Development Facilitation Team (DFT) – Review Comments

DRB Project No: PR-2019-002874 Date: 04/24/2024 Agenda Item: #7 Zone Atlas Page: B-13

Request: SUBDIVIDE TRACT C, COTTONWOOD POINT SUBDIVISION, 6.771 ACRES, INTO LOTS C-A AND C-2 AS A MINOR PLAT ACTION AND TO GRANT 3 EASEMENTS BY THE PLAT (ONE PRIVATE DRAINAGE EASEMENT AND 2 PUE FOR PNM)

Application For: SD-2024-00024- PRELIMINARY/FINAL PLAT (DFT)

PLAT OF  
**LOTS C1, C2, AND C3**  
**COTTONWOOD POINTE SUBDIVISION**  
 BEING A REPLAT OF TRACT C, COTTONWOOD POINTE SUBDIVISION  
 WITHIN PROJECTED SECTION 07, T 11 N, R 3 E, N.M.P.M.  
 TOWN OF ALBUQUERQUE GRANT  
 CITY OF ALBUQUERQUE  
 BERNALILLO COUNTY, NEW MEXICO  
 NOVEMBER 2022

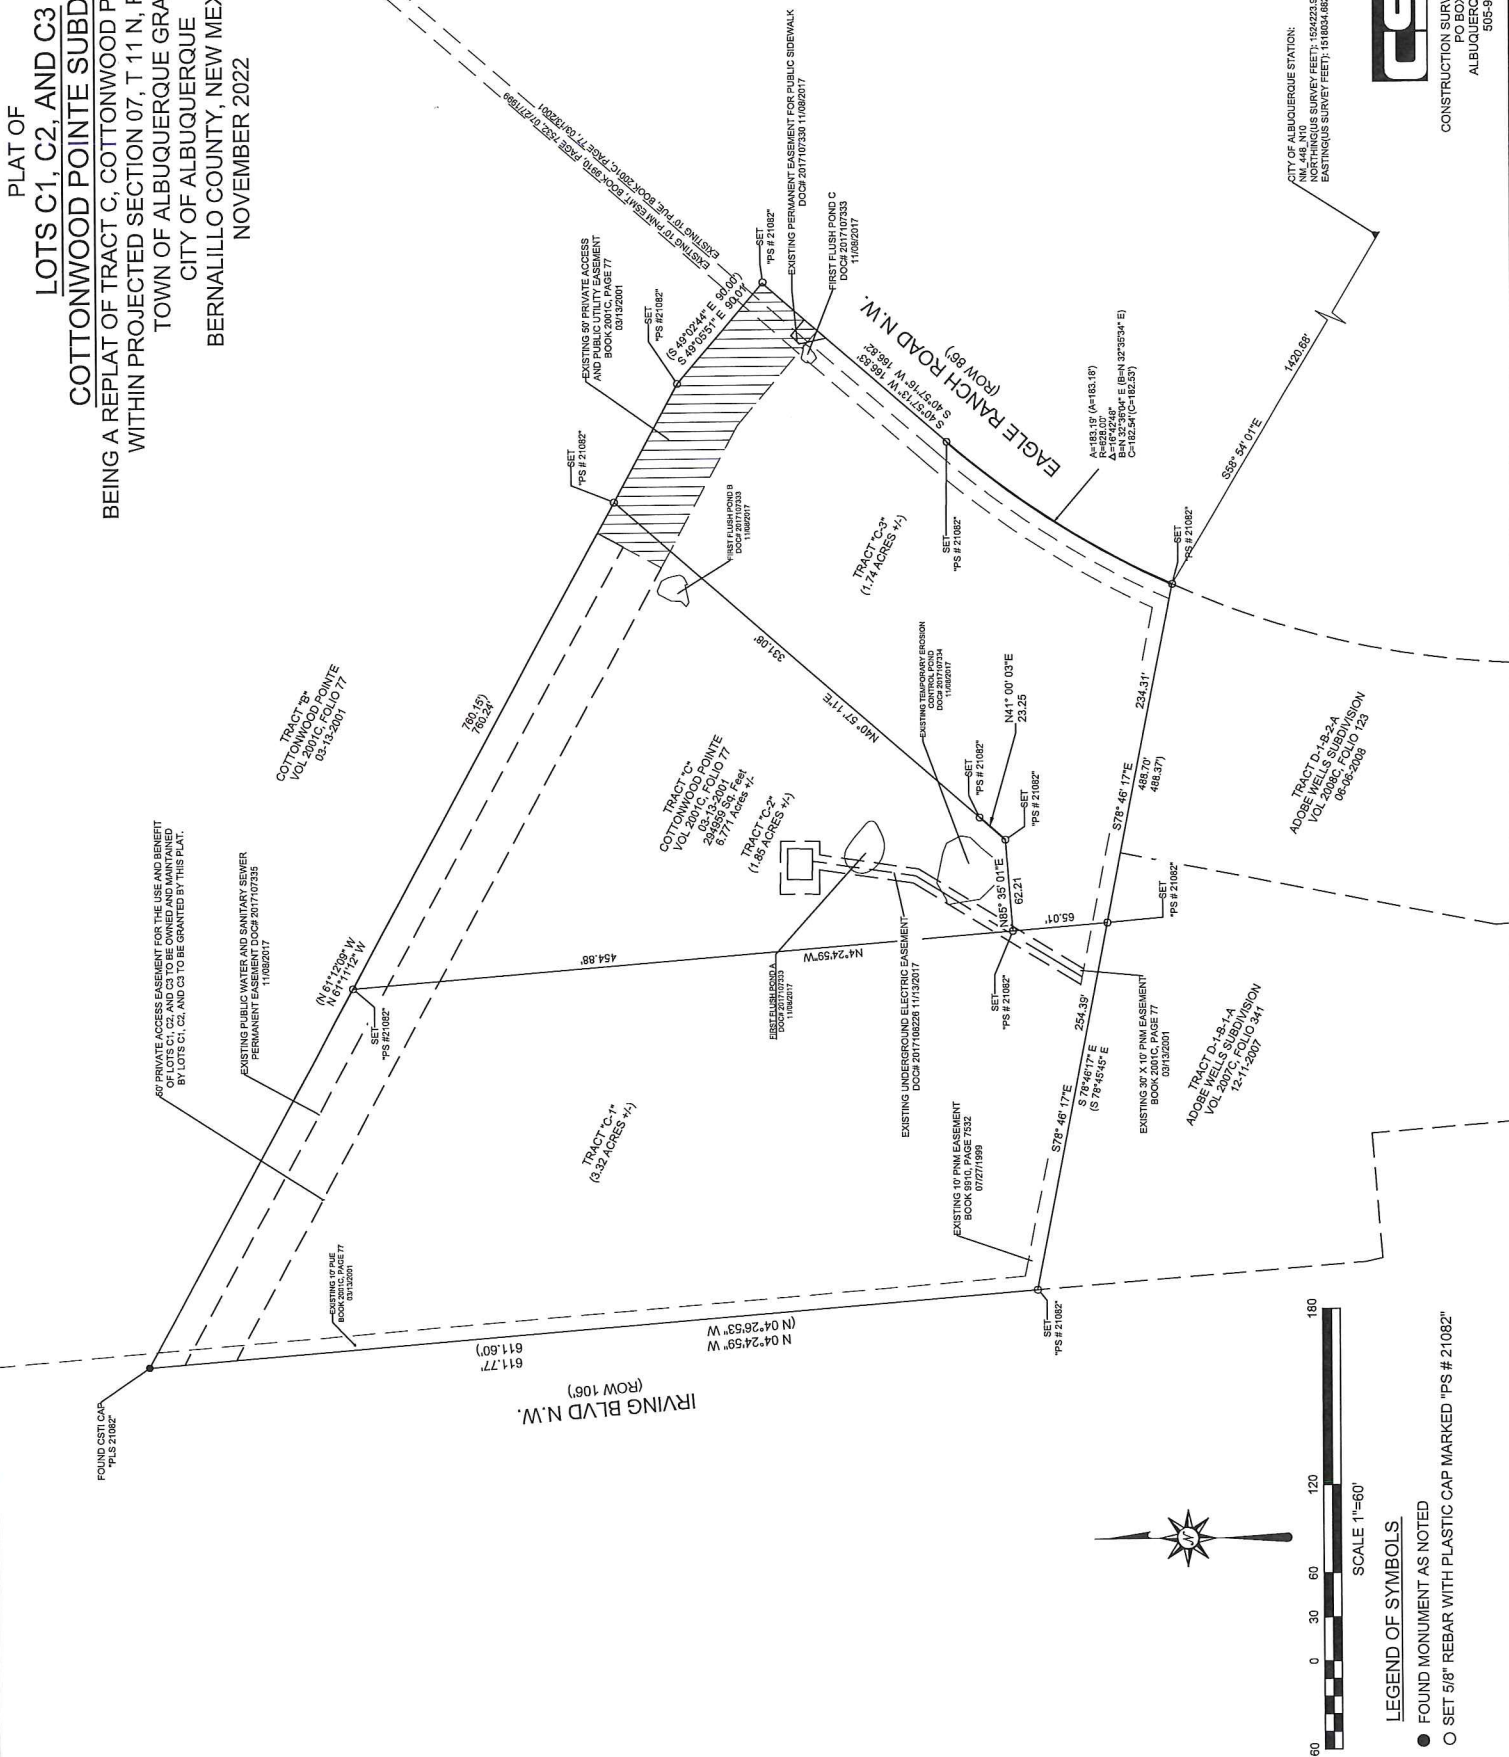
1. No objection to the proposed plat.
 - a. For signature, please provide a clear copy of the plat. Currently, it is difficult to read some of the information. The 50 easement with water and sewer use noted, appears to be the hatched area. Please clearly identify that portion.
2. For information:
 - a. For future development, request an availability/serviceability statement online at the following link www.abcwua.org/Availability_Statements.aspx. Requests shall include fire marshal requirements.
